From: Michael Eastham
Sent: 20 October 2017 18:59
To: Planning.Responses
Subject: FW: Saltbox, Bognor Regis - Heads of Terms

From: Nia Russell [REDACTED]
Sent: 20 October 2017 15:13
To: Michael Eastham
Subject: Re: Saltbox, Bognor Regis - Heads of Terms

From: Nia Russell [REDACTED]
Sent: 20 October 2017 11:35
To: Michael Eastham
Cc: Arfon Hughes
Subject: Re: Saltbox, Bognor Regis - Heads of Terms

2A: With Acoustic Barrier L_{Aeq}

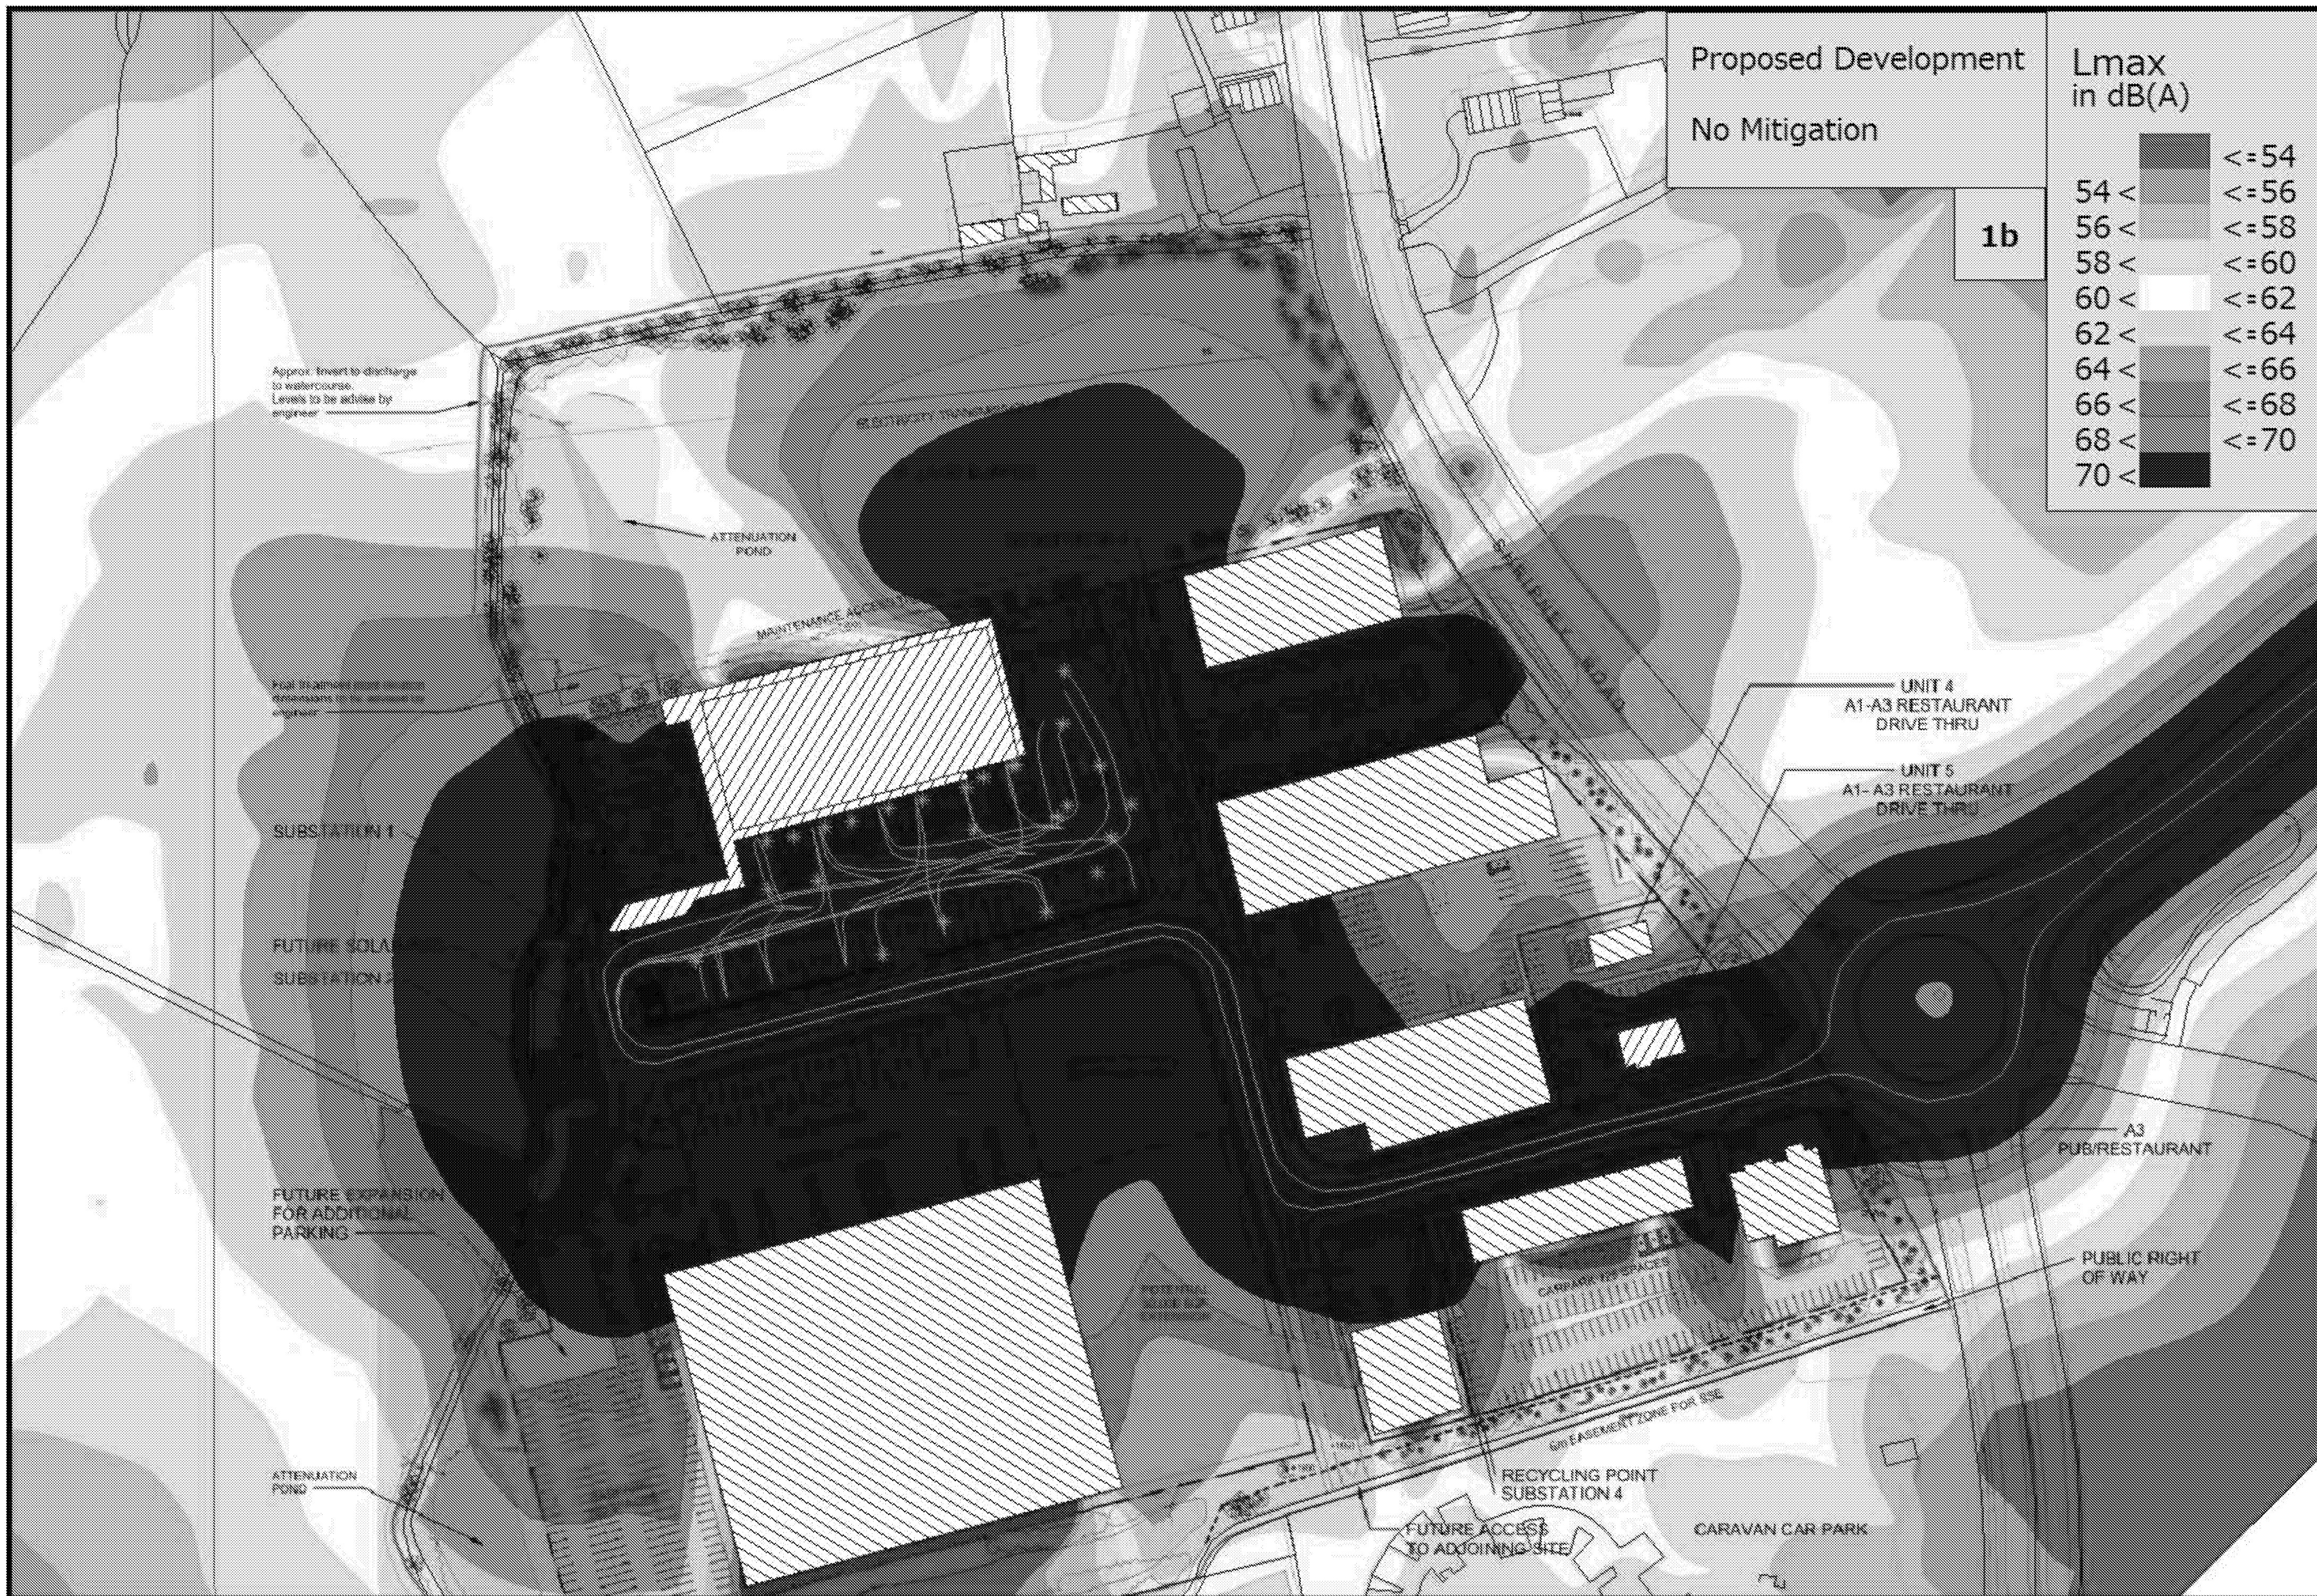
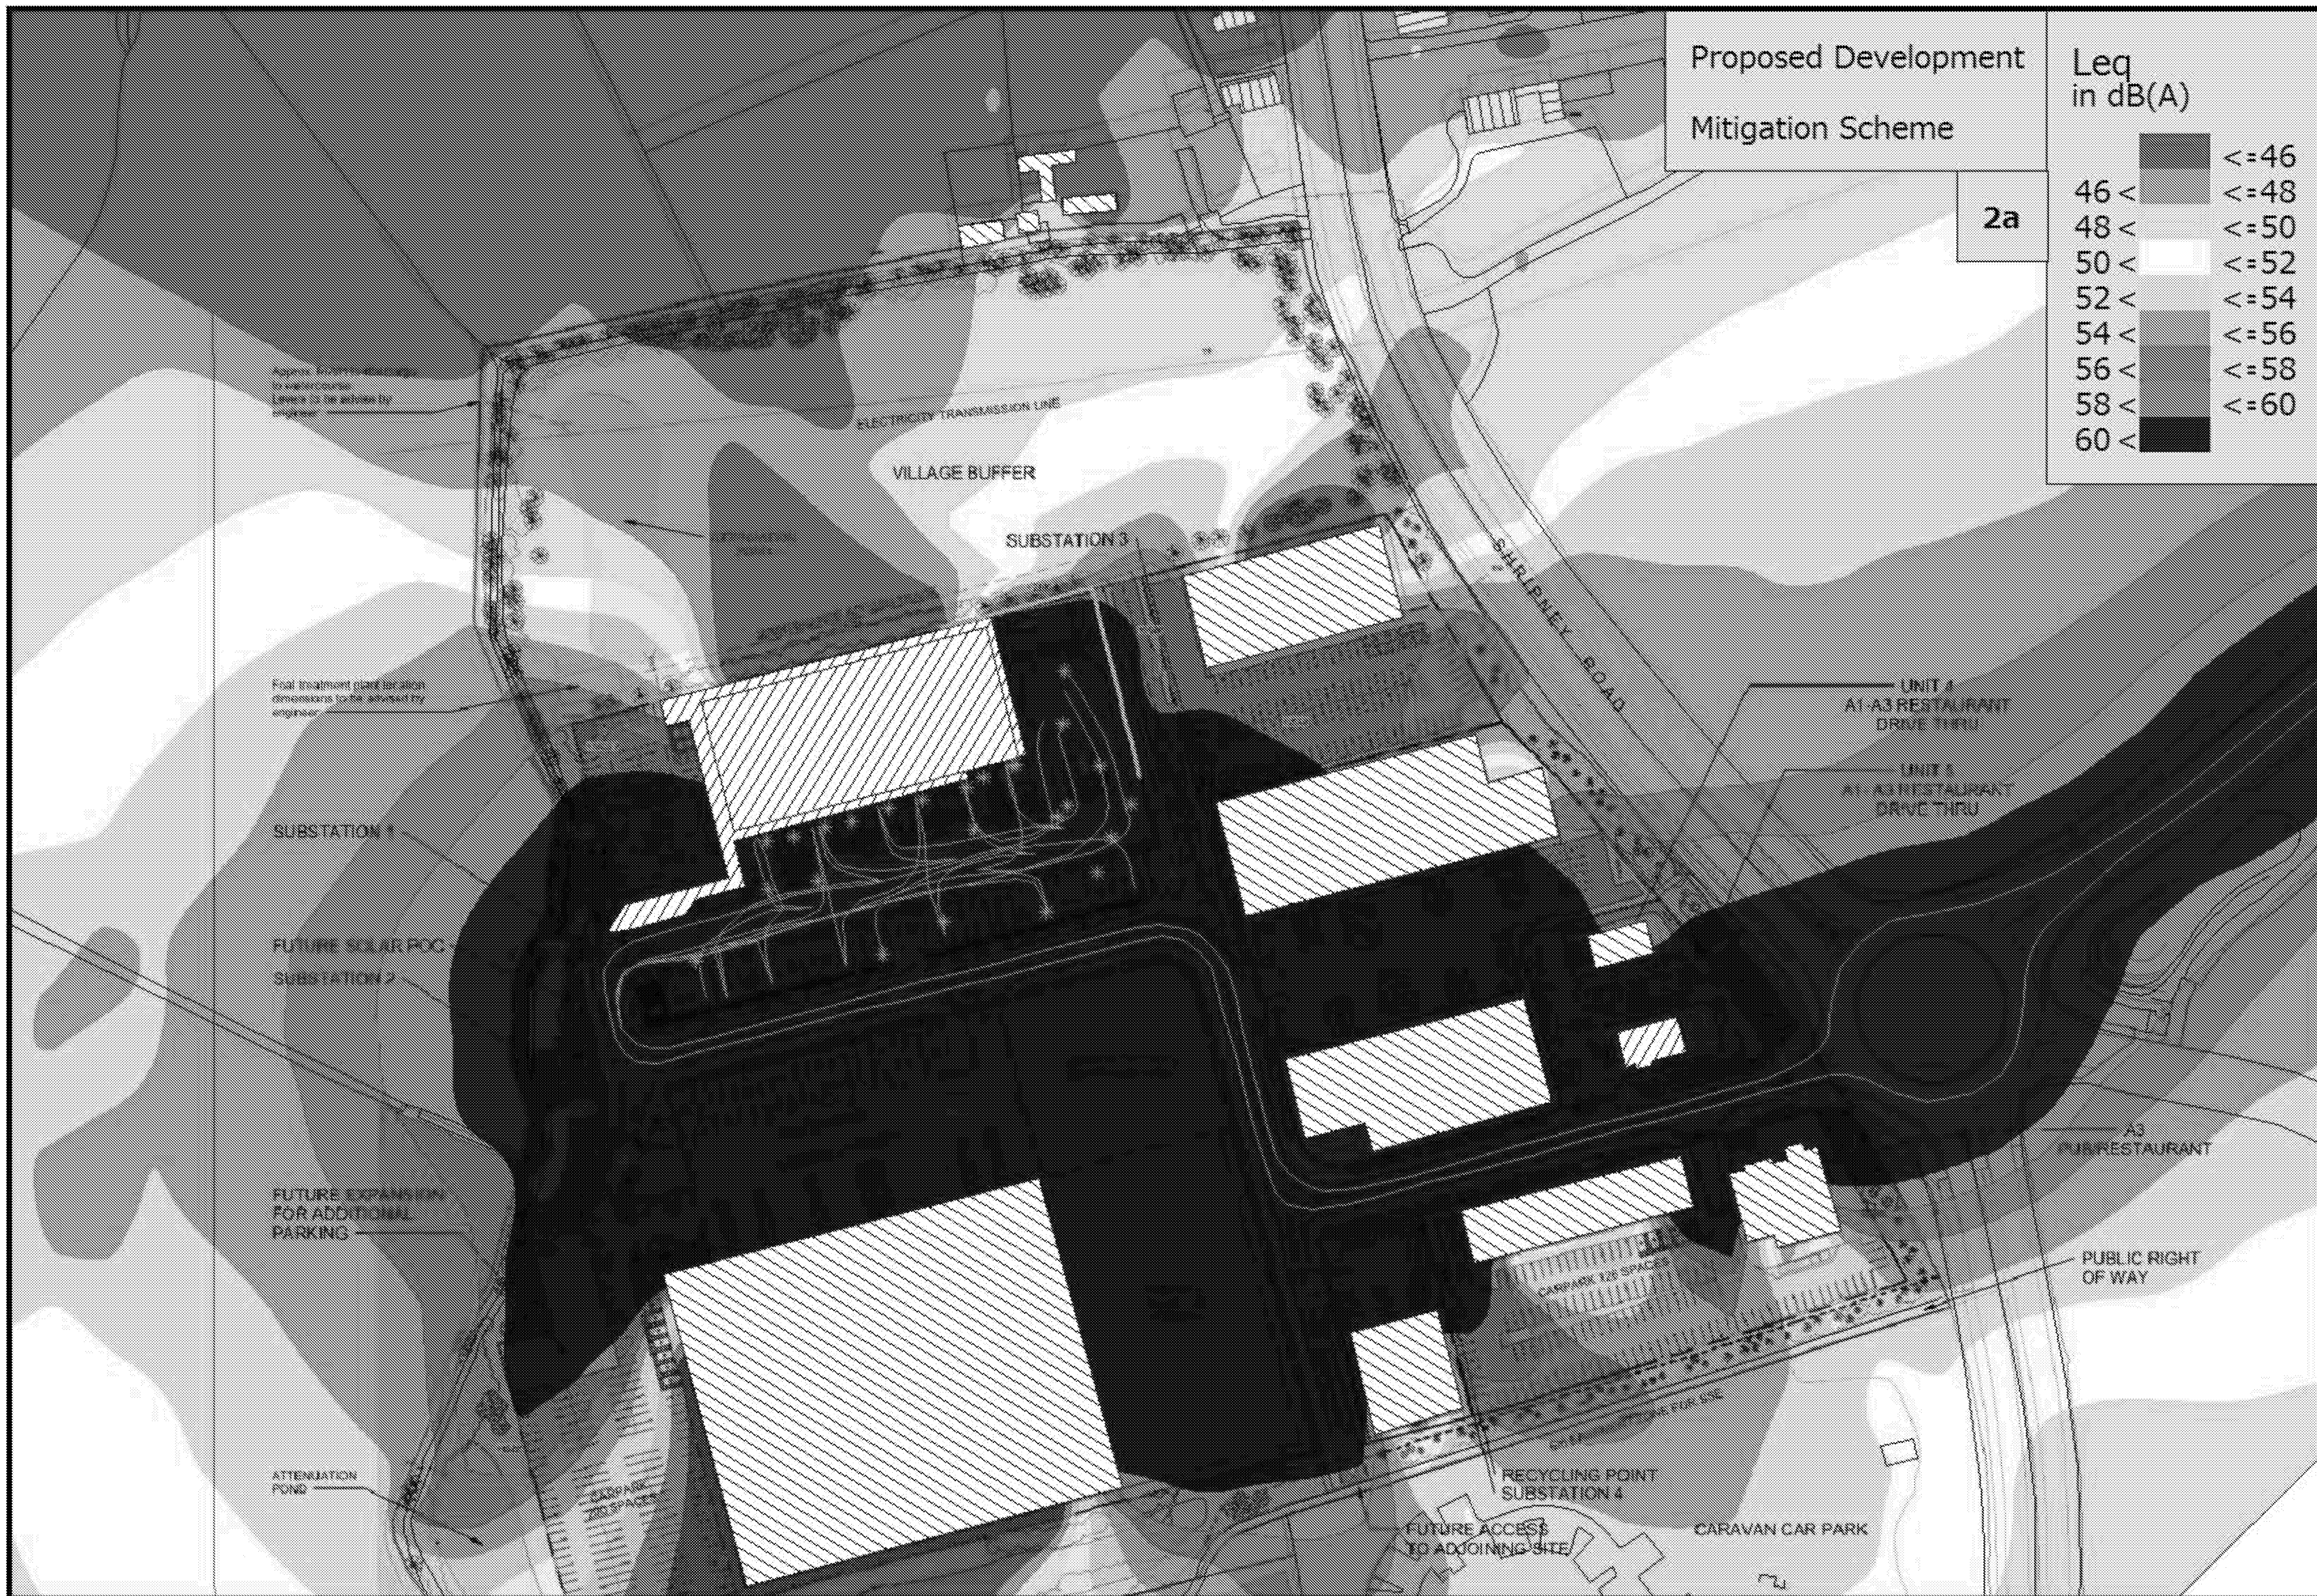
- 1) Does the Unit need to have security fencing (and gates) around it?
- 2) Does the acoustic fencing need to be 4.0 metres high? Could it be lower in height?

In relation to the acoustic fence, In the acoustic report, at item 4.24 the acoustic engineers state that to screen and protect sufficiently, the development requires a 4m high acoustic barrier formed with tanalised timber feather edged close board fencing. We have asked the engineers to re-run their model to explore if there is potential for the height to be reduced and I will update you of the outcome of that exercise as soon as I am able to.
